**Subject:** RE: Planning Consultation on: A/104/19/RES

Engineers Comments Regarding Surface Water Drainage

**APPLICATION NO: A/104/19/RES**

**Site Address:** Crete Nursery Dappers Lane Angmering BN16 4EN

Filter Drain Structure

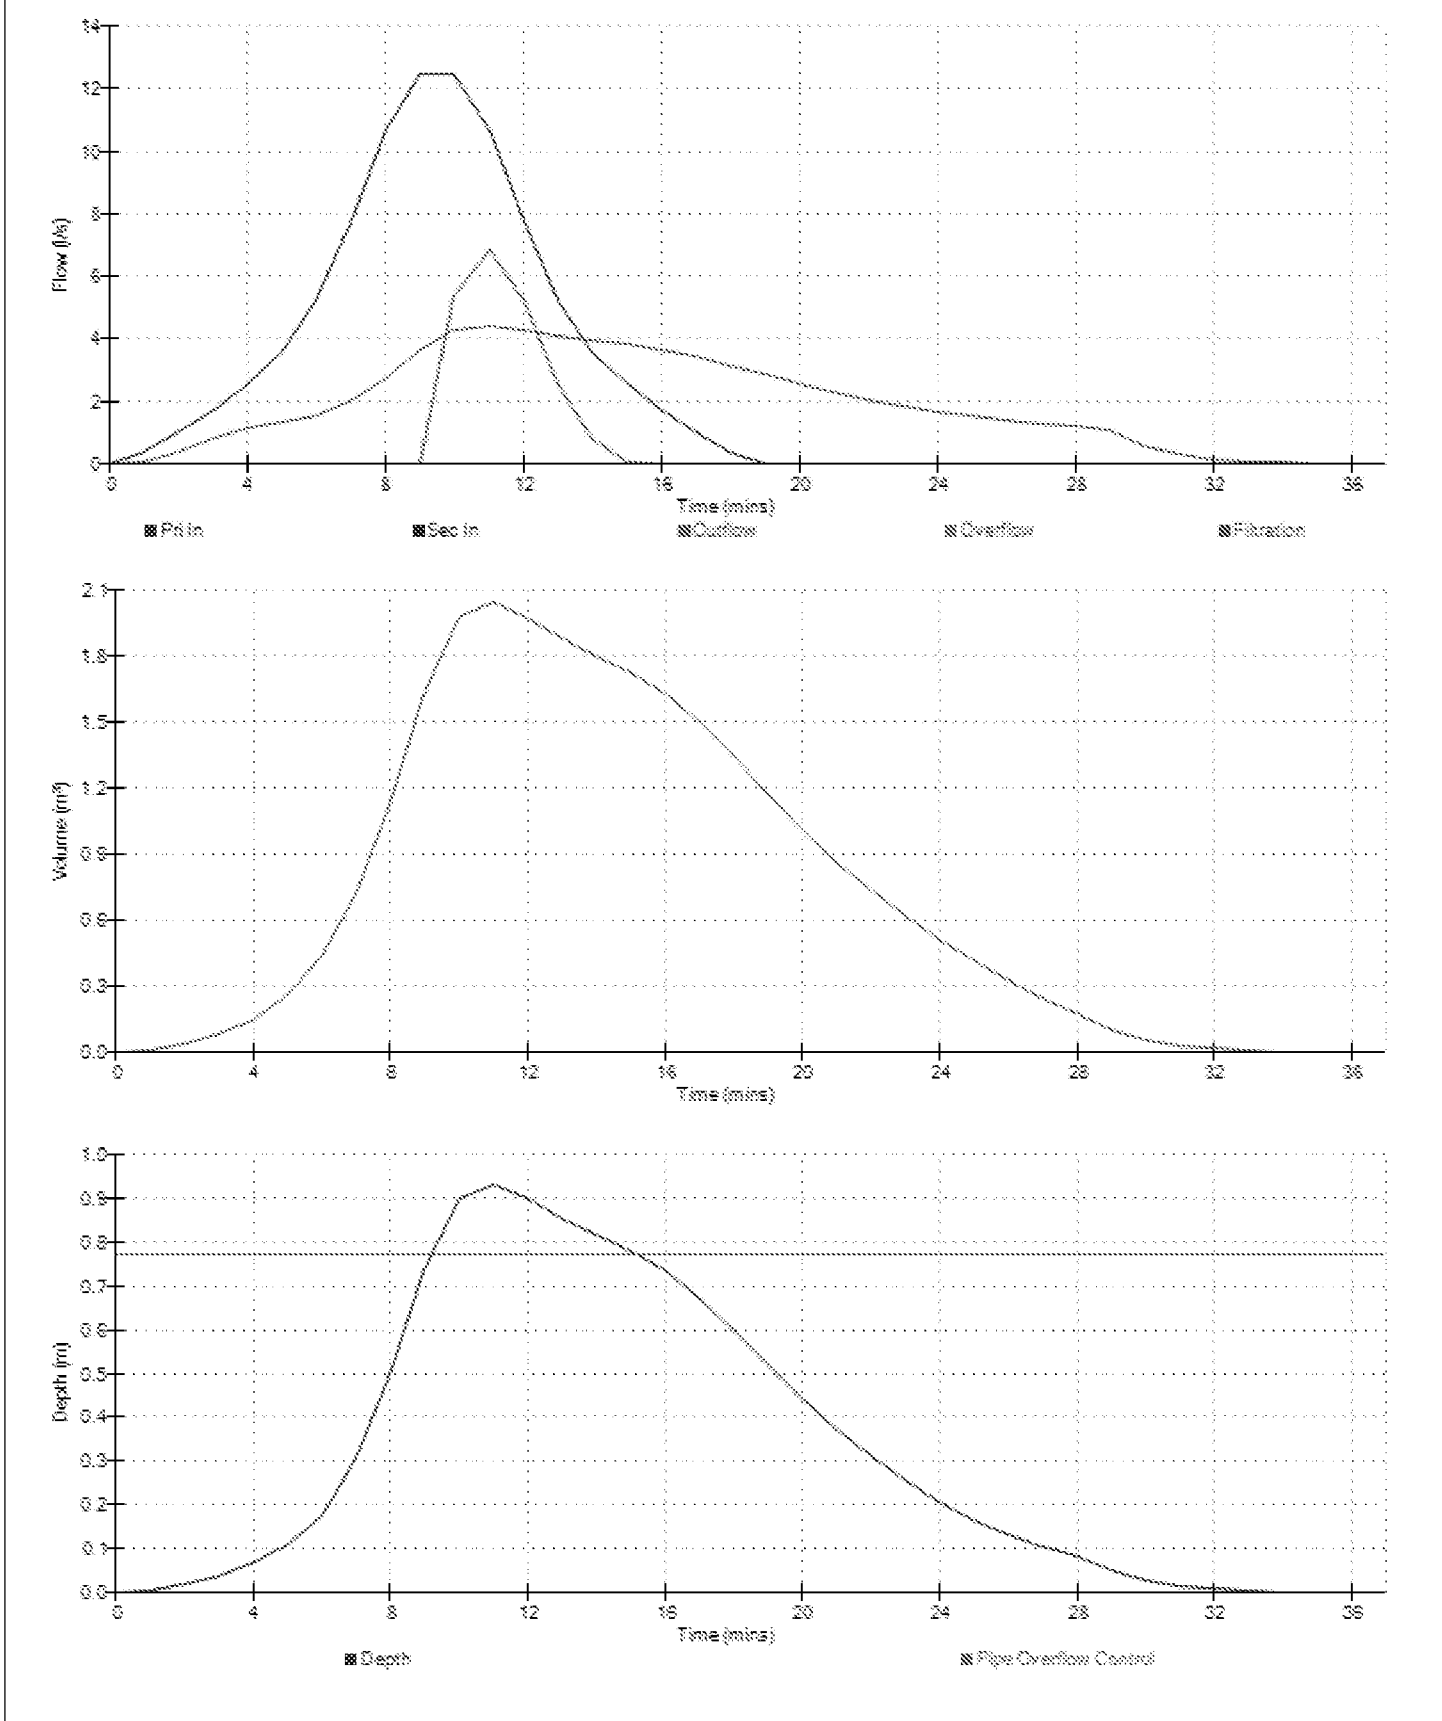
3. Please can an impermeable areas plan be provided that clearly shows the impermeable areas draining to each surface water drainage feature.
4. The filter drain is inadequate. Maximum modelled water depths are nearly 1m. This clearly will not be able to be contained above maximum recorded groundwater level.

5. From looking at cross sections it also appears that the filter drain will be on a slope, please ensure this is accurately depicted within calculations.

7. A permeable liner should fully wrap around the sub-base of the permeable paving areas.
8. Please confirm material specification for filter drain. All sub-base material should be no fines.

##### Porous Car Park

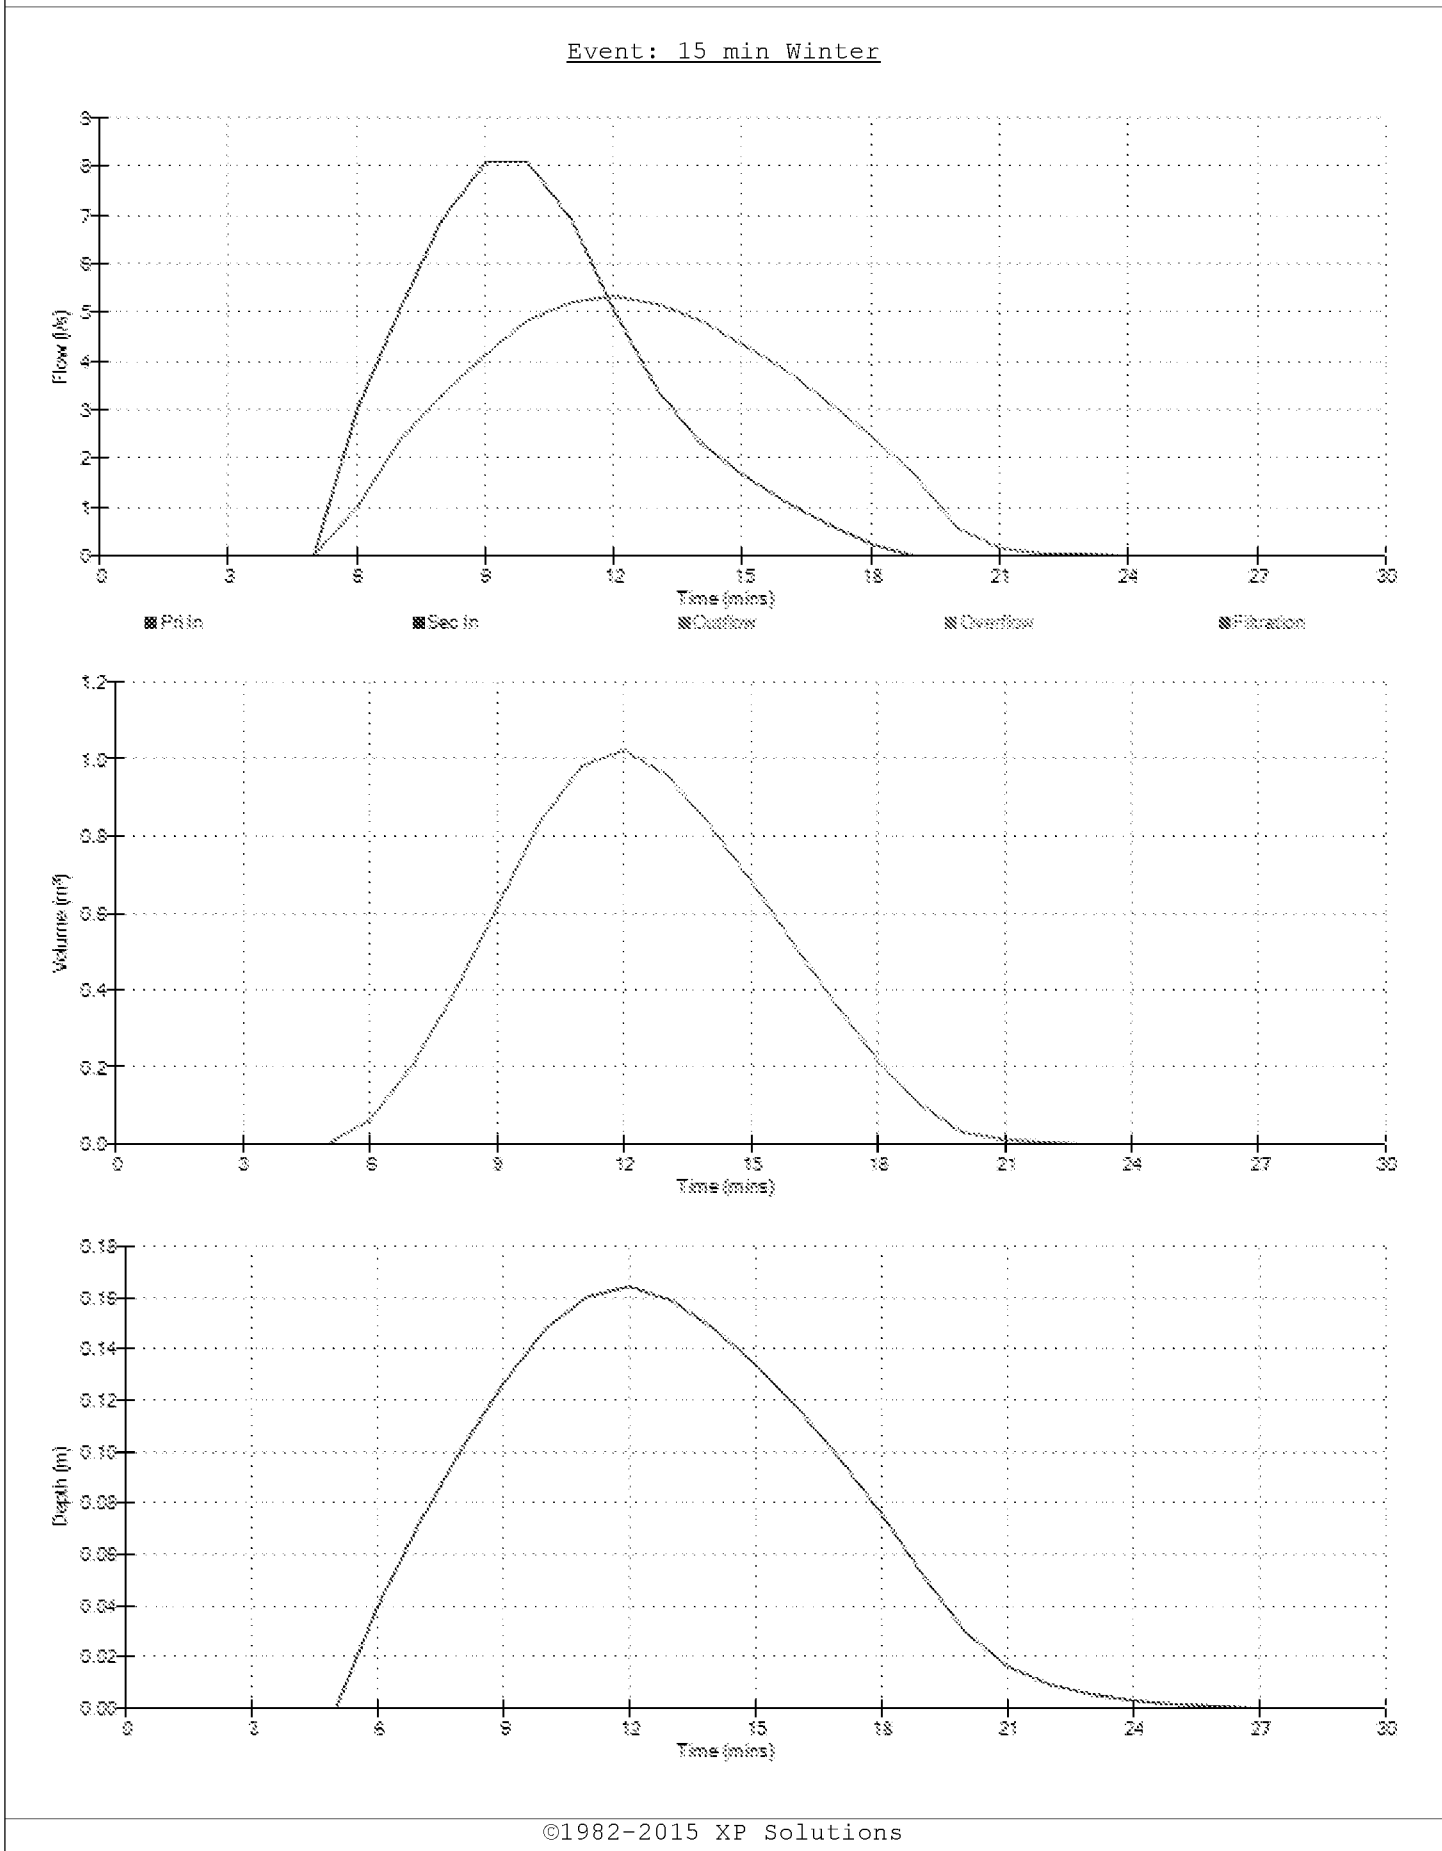
6. Please provide evidence that a resin bound surface with open surface course asphalt is permeable. We have significant concerns over the permeability of this type of surface now and over the design lifetime.

11. Please provide invert levels and cover levels of all inspection chambers, manholes, filter drains, etc. Please also ensure that finish and formation level of permeable paving is clearly provided on plan.
